**EL PASO COUNTY PLANNING AND
 COMMUNITY DEVELOPMENT
 DEPARTMENT**

GRADING AND EROSION CONTROL PLAN CHECKLIST

Revised: July 2019

CROSSROADS MIXED USE  
COUNTY OF EL PASO, STATE OF COLORADO  
GRADING & EROSION CONTROL  
PLANS  
NOVEMBER 2020

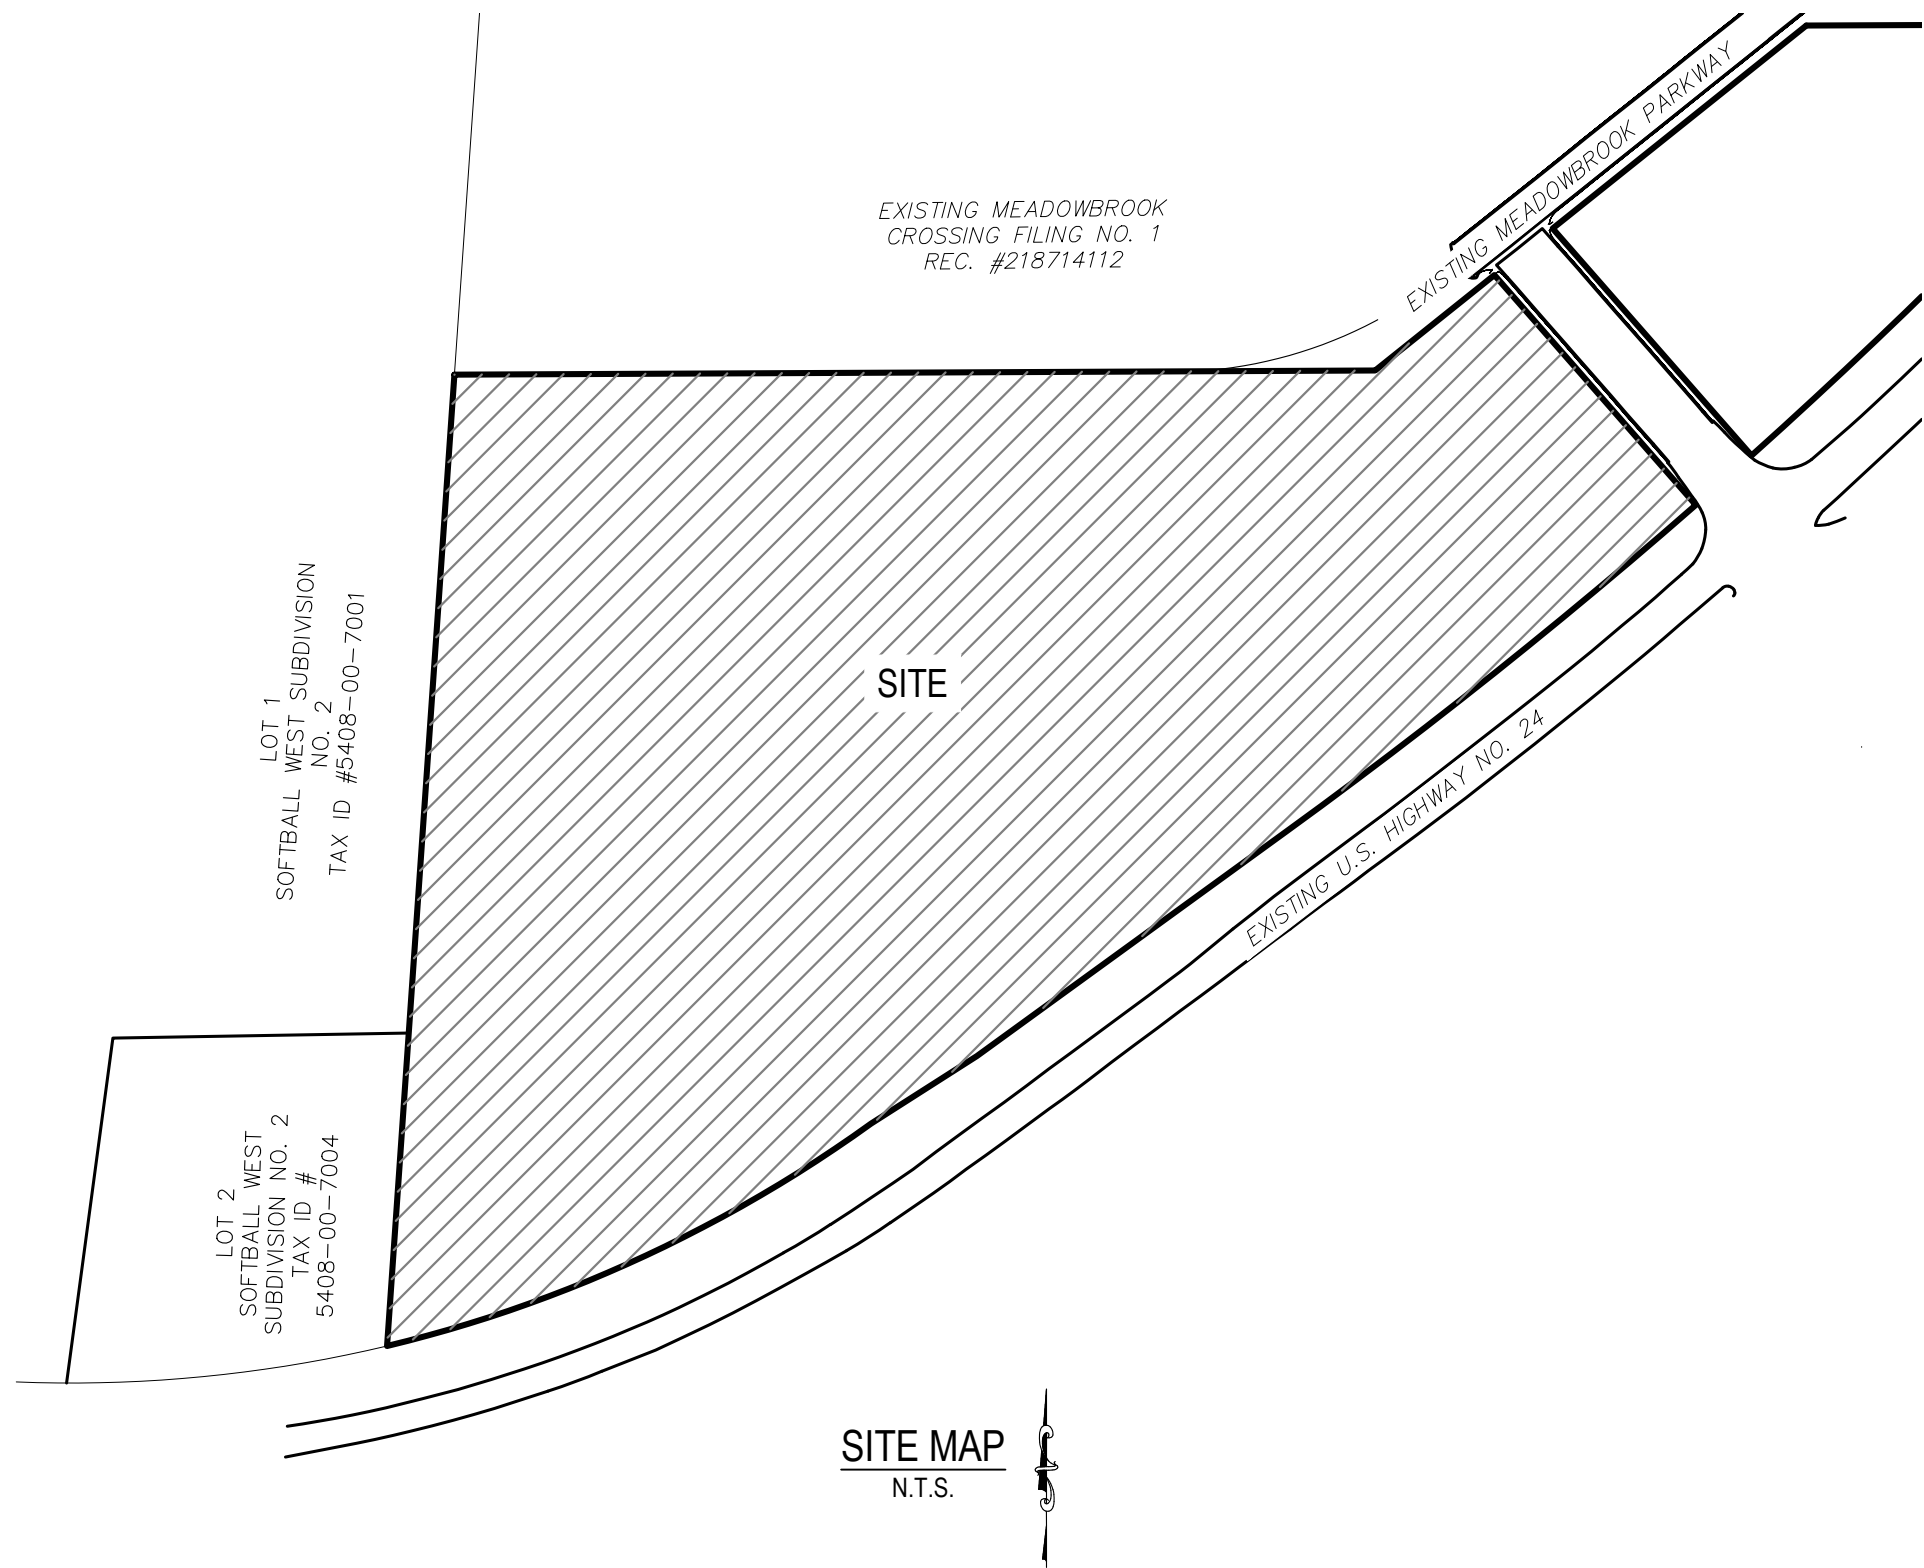
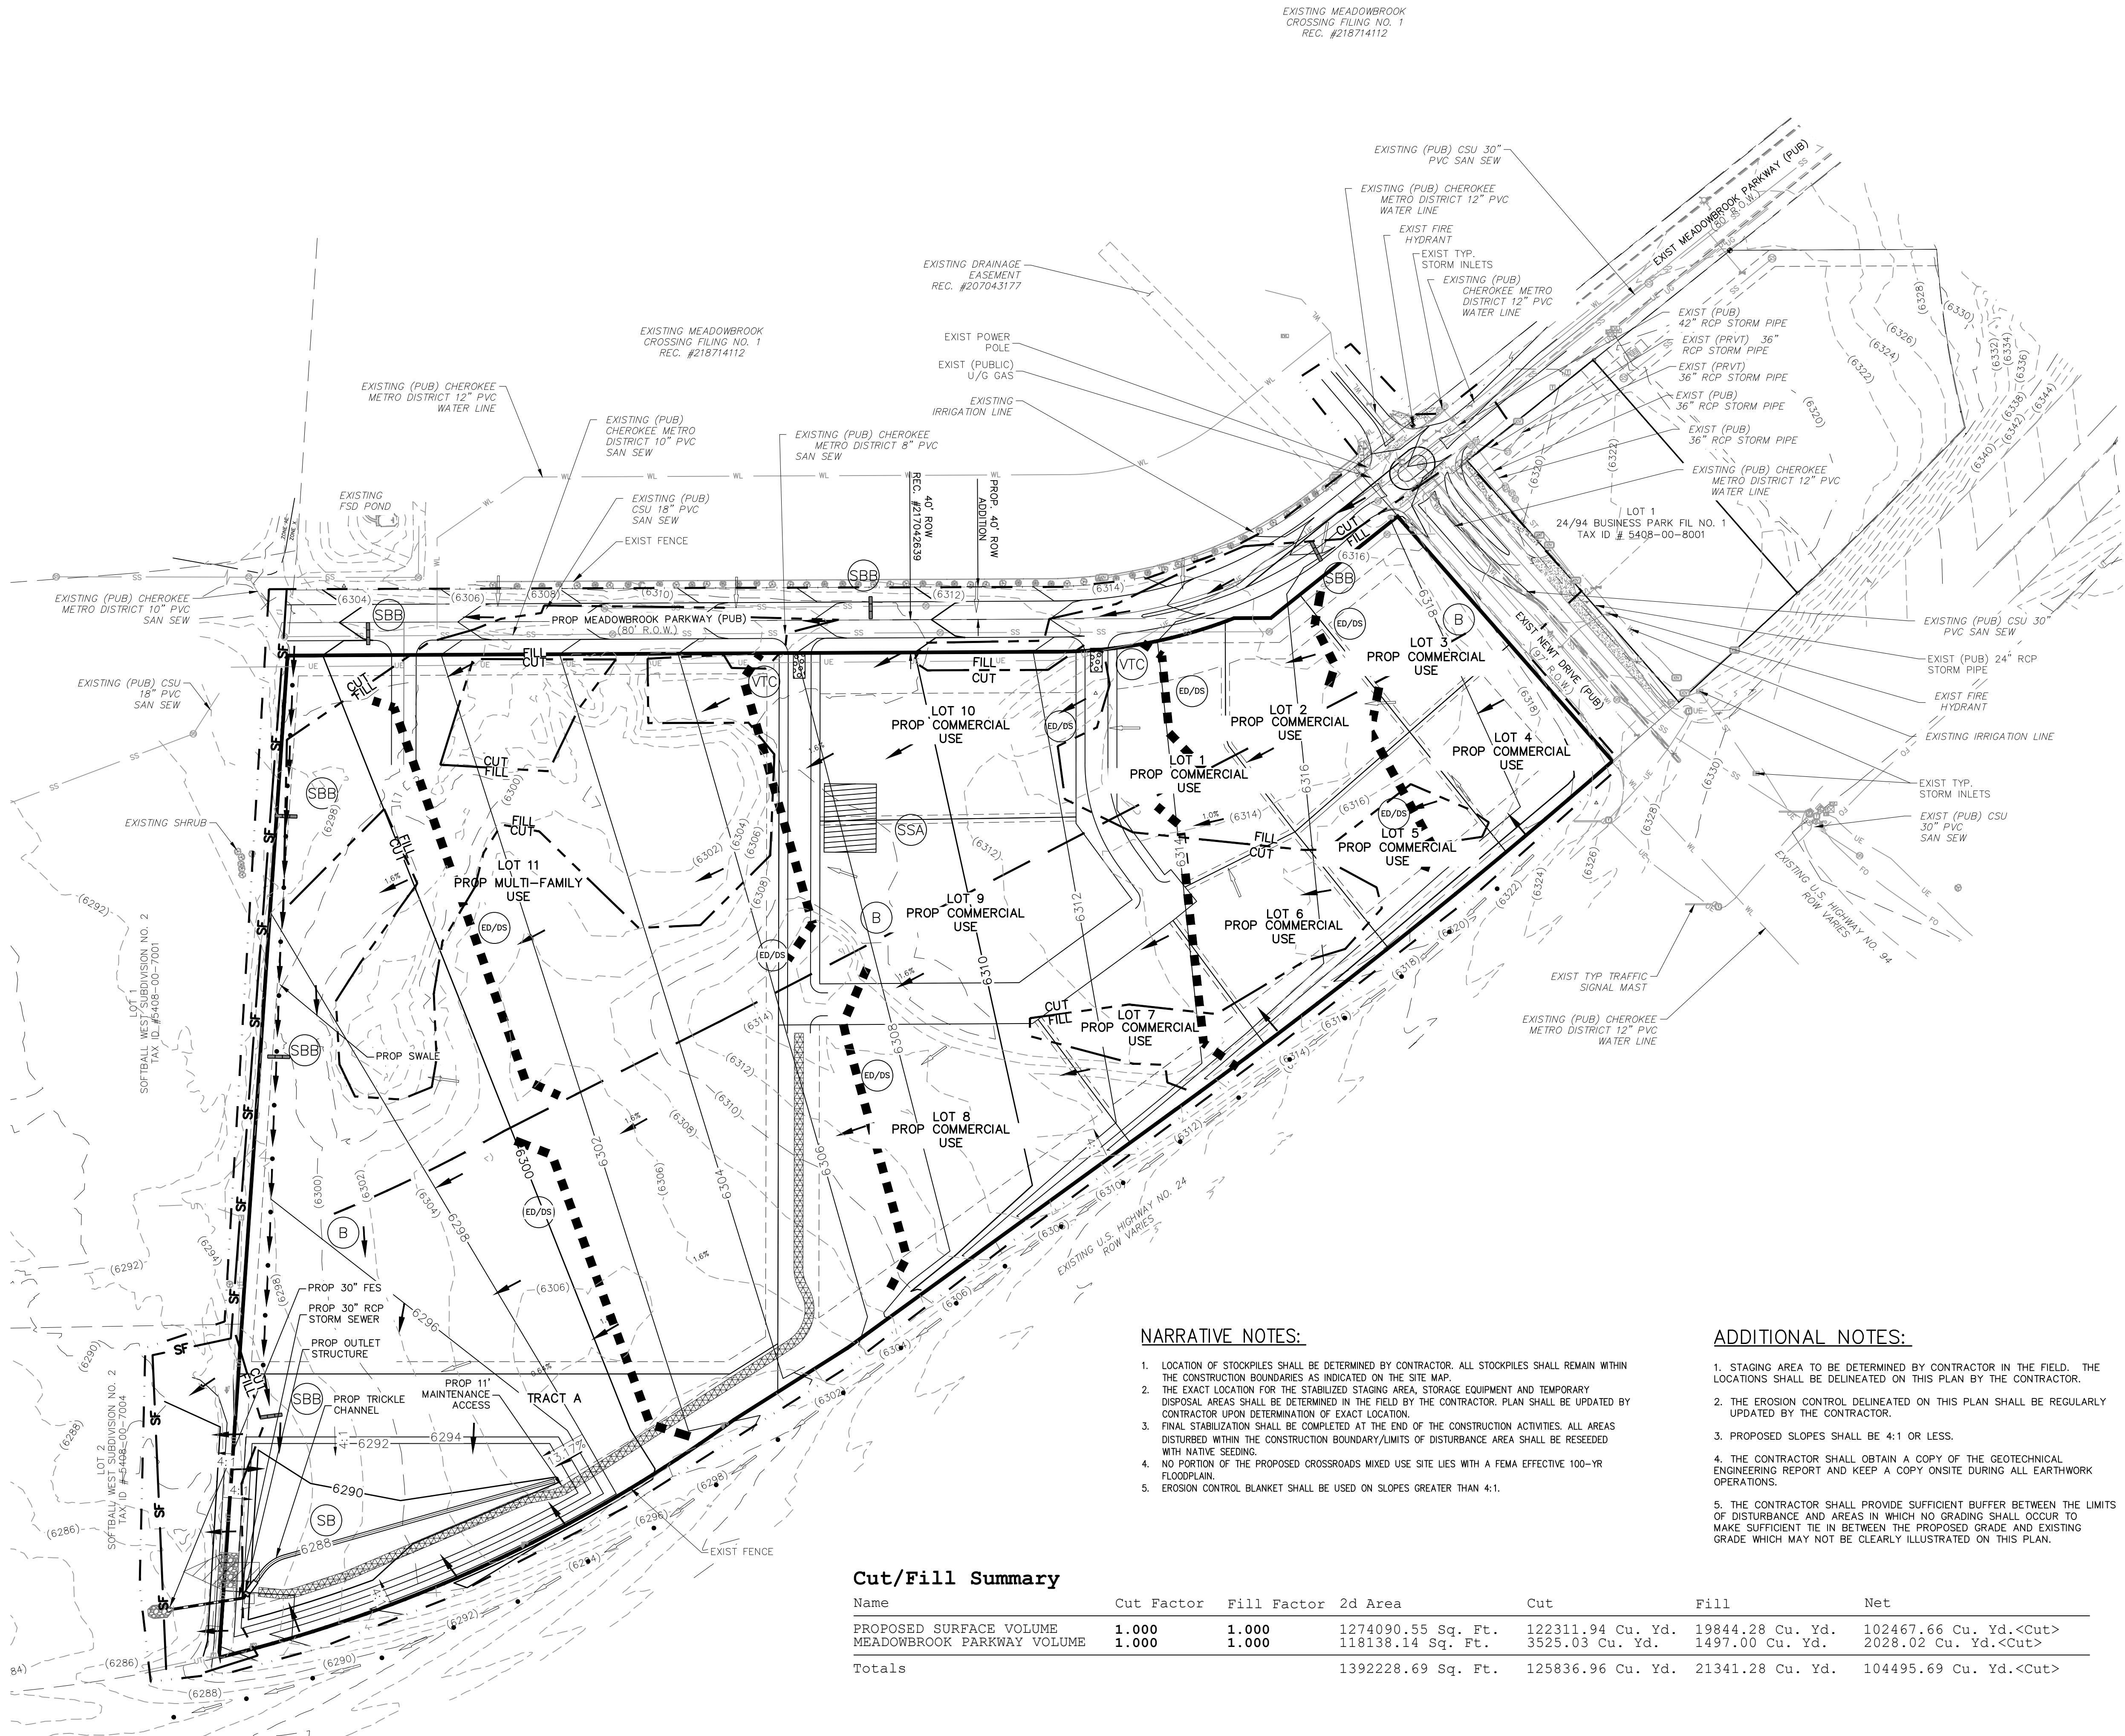
Revise sheet 1 of GEC plans to match all of these notes.
